M54 to M6 Link Road
TR010054

**8.8LIU(I) Draft Statement of Common
Ground with Ian Simkin & Adrian
Simkin**

**M54 to M6 Link Road
Development Consent Order 202[]**

Version	Date	Status of Version
1	October 2020	Draft for landowner review

Drawing Title: **FIGURE 2.2 ENVIRONMENTAL MASTERPLAN KEY PLAN (REVISION 3)**

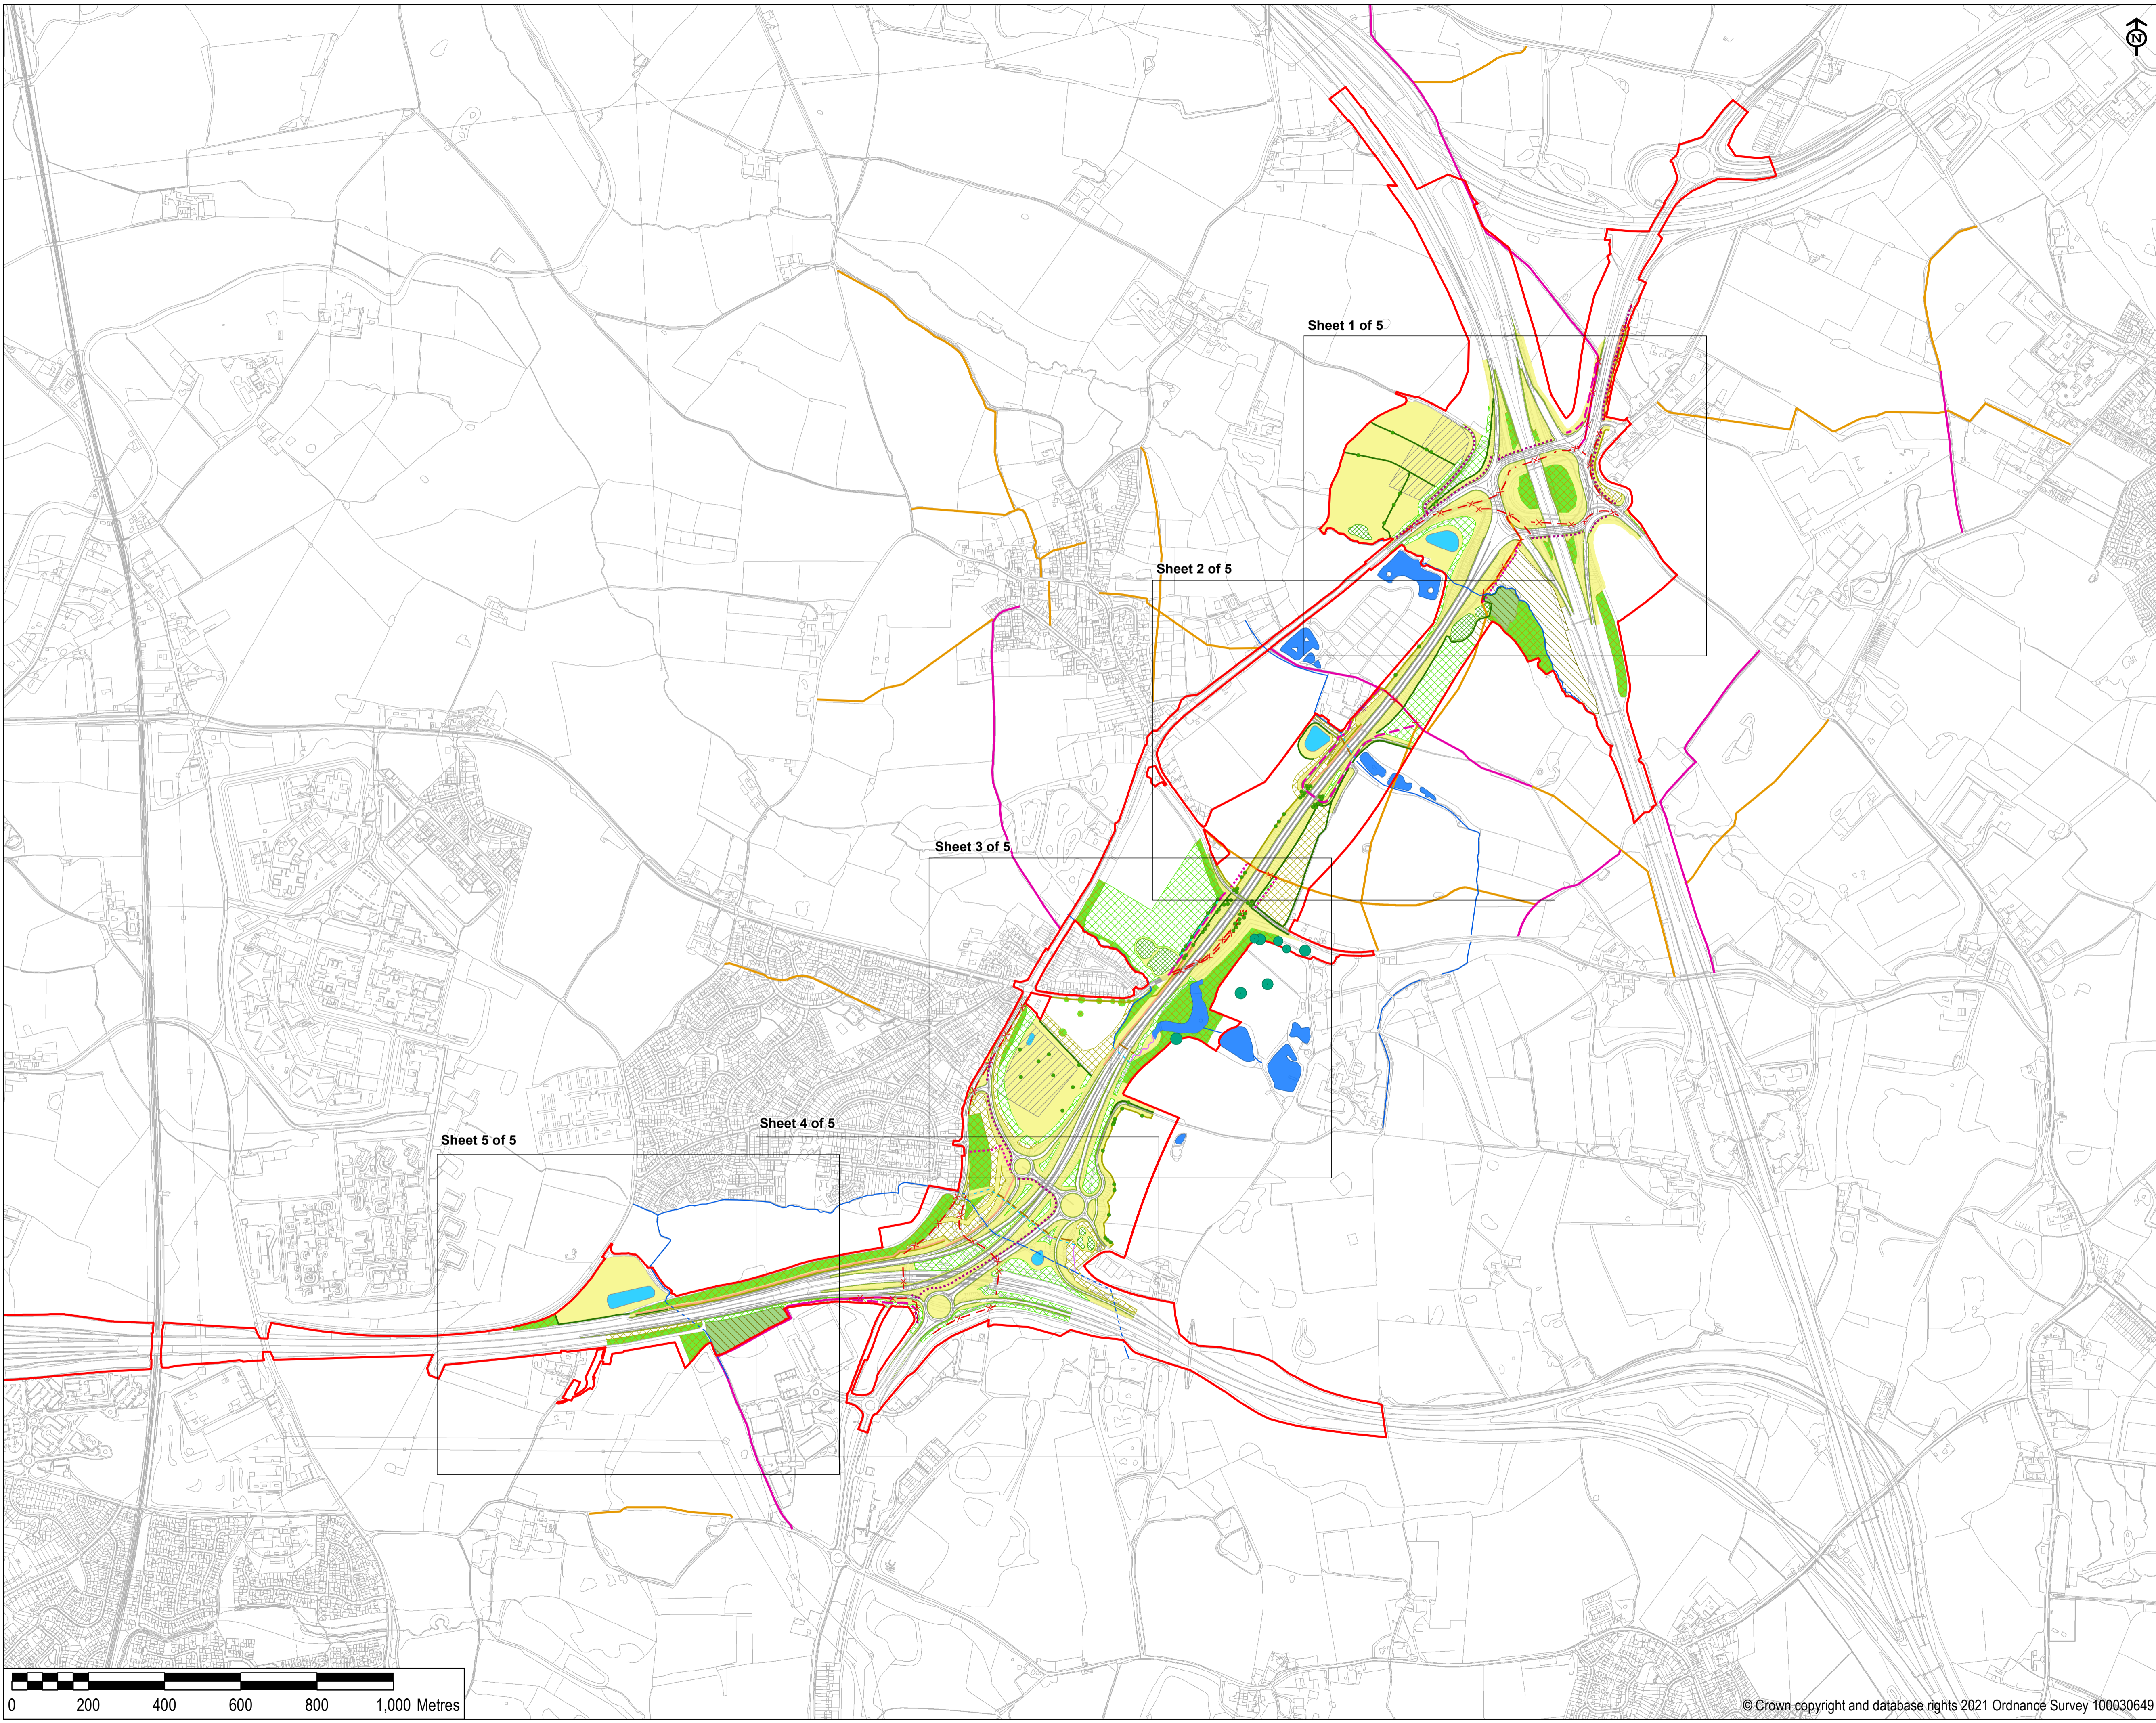
<p>The permanent acquisition of plots 5/26, 5/27, 6/25 and 6/23 for environmental mitigation is objected to as it is considered excessive for the offsetting of only approximately 0.79 ha of arable land being taken for the road construction and we do not accept that the extent of the land proposed to be taken for mitigation, at 3.504 ha, is necessary and proportionate for environmental mitigation.</p>	<p>of the Scheme, HE has proposed to change the Environmental Masterplan [proposed changes versions AS-086 to AS-092/6.2] [so that environmental mitigation is no longer present on these plots and the plots are therefore not required to be acquired on a permanent basis. This change will be implemented if accepted by the Examining Authority. The northern part of plot 6/25 is still required temporarily for soil storage during construction, but would be reinstated to its previous condition and returned to the landowner after construction.</p> <p>One reason that this land was selected for removal from the Environmental Masterplan was in recognition of its status as Best and Most Versatile (BMV) agricultural land as highlighted by Messrs Simkin' representation made on 28/01/2020 as well as Natural England.</p>

<p>which remains to be acquired temporarily, has an unexplained outlined area within, absent of a reference to it on the legend. Therefore, we cannot comment any further until such time as clarification of what the pink outlined area represents is provided to us, which was requested from HE on the 7th September 2020.</p>	<p>this plot would also only be required on a temporary basis.</p> <p>.</p> <p>Clarification on the purpose of the area outlined in pink/ purple was provided via email to the land agent on 14/09/2020. It was also annotated on the plan published on 24 August showing the changes to the Masterplan (comment EM3).</p>			
Compensation	Letter from Bagshaws, 28/01/2020	<p>'Our clients have been approached by a number of developers for commercial development of this land and as such would be claiming hope value if permanent acquisition is required.'</p>	<p>Compensation values will be determined by the District Valuer.</p> <p>Highways England sent draft Heads of Terms to the landowners dated 15/07/2020 and have received no response to date.</p>	Under discussion	Medium	Medium

Bridleway realignment	Letter from Bagshaws, 28/01/20	Plot 6/31 is shown as a narrow blue line on the road scheme plan and detailed in your interest schedule to be required temporarily and rights to be acquired permanently. We can only assume this relates to the proposed position of a public bridleway, however, it	Plot 6/31 is in the correct position. The blue shaded area indicated the rights area required for the realignment of the bridleway. This is indicated as a corridor to include the horizontal limits of deviation for the adjacent highway which accounts for the slight variation in marked location. The proposed location is as per the Draft Environmental Masterplan (as	Under discussion	Medium	Medium

does not appear to sit in the correct position on the Draft Environmental Masterplan dated 8th November 2019, revision PO9. When scaled off the bridleway was in an entirely different position to that shown on the road scheme plan.'	presented at November 2019 supplementary consultation) which currently sits within Plot 6/23 however as the route runs alongside the bottom of the embankment it is necessary to provide a corridor to account for the horizontal limits of deviation therefore the blue area shown is the edge of the corridor.			
	Land agent's response to the consultation on changes to the DCO, also raised in land agent's Relevant Representation RR-033 and letter received from Bagshaws dated 28/01/2020	(With regards to Change 7) We note the previously objected to acquisition of plot 6/31, for the provision of a bridleway, Saredon BW13, which terminates at M6 Junction 11, still remains as part of the scheme on both the revised land plans and Environmental Masterplan overview revision plan. The Bridleway is not used, and has been unused for many years, it is	The bridleway is a PRoW and the Applicant is required by policy and legislation to retain connectivity of PRoW where possible. Lack of use is not sufficient justification by itself to extinguish a PRoW. The Scheme seeks to maintain existing levels of non-motorised user connectivity as a minimum requirement. The route currently connects into M6 Junction 11 where crossing facilities are provided to enable connectivity over the M6. The Scheme proposes to improve the crossing facilities for non-motorised users at M6 Junction 11. This route provides a connection between M6 Junction 11 and Great Saredon therefore it is anticipated that this route will be required to be re-instated and	Under discussion	Medium	Medium

Land agent's Relevant Representation RR-033	<p>If it is held that land has to be taken for environmental mitigation, then we would welcome the opportunity to discuss terms of the retention of the freehold, but</p>	<p>Should the design changes submitted on 9 October 2020 be accepted by the Examining Authority, no land owned by Ian and Adrian Simkin would be permanently acquired for the sole purpose of environmental mitigation. Should the changes not be accepted by the Examining Authority, Highways</p>	Under discussion	Medium	High

subject to a management agreement for the management of the land in an environmentally beneficial way to help satisfy environmental mitigation requirements of the scheme.	England is willing to continue discussions on the potential management arrangements post construction, to be secured via agreement. Any agreement would need to ensure that landowner adheres to maintenance requirements in line with that required on the DCO, if made.			
	Land agent's response to the consultation on changes to the DCO	(With regards to Change 7) We agree with the proposed reduction in order limits at this location, which removes the south eastern section of my client's land at plot 6/25. In addition, we welcome the removal the species-rich grassland habitat creation across the whole plot, following the review of the extent of mitigation across the scheme. On review of the Environmental Masterplan overview revision plan, the remainder of plot 6/25,	The Environmental Masterplan published for consultation on 24 August 2020 showed a pink/ purple outline on plot 6/25. This area would be used for temporary soil storage during the construction of the Scheme. This boundary is not shown on the Environmental Masterplan issued with the Scheme changes on 9 October 2020. As recognised by the landowner, the area covered by plot 6/25 located to the south-east of M6 Junction 11 is proposed to be significantly reduced by the Scheme changes. This means that plot 6/25 is significantly smaller on the revised Land Plans submitted on 9 October 2020 than in the current Land Plans [AS-007/2.2]. If changes are accepted by the Examining Authority,	Under discussion	Medium	Medium
